Letter No. **A1/40383/2003**

Sub: **CMDA - Planning Permission -
Construction of Ground floor and
First floor - Commercial Building at
S.No.251/6A3 of Thiruniaravur Village -
Development charges and other charges to be
remitted - Reg.**

SITE PLAN CUM GROUND FLOOR PLAN

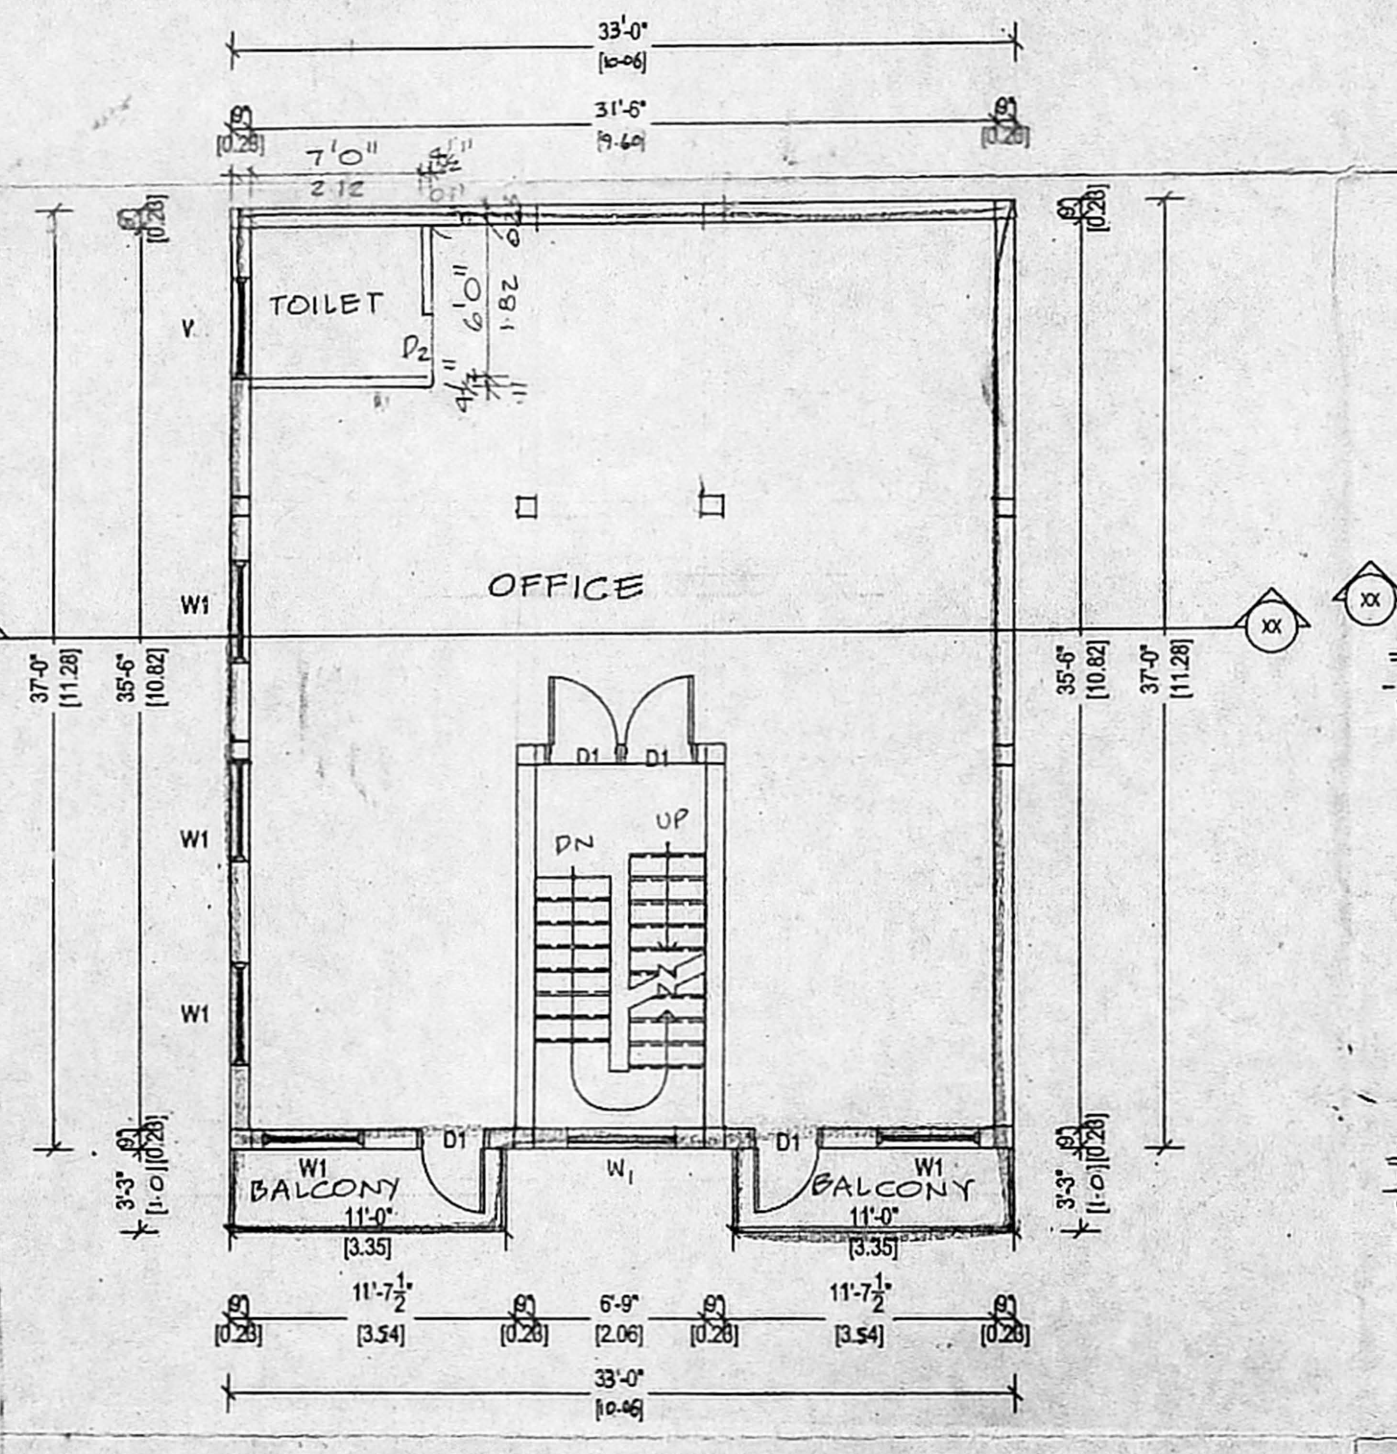
- a) Rain water conservation regulations stipulated by CMDA should be adhered to strictly.
- b) **Five copies of Revised plan indicating the steps from Ground floor.**
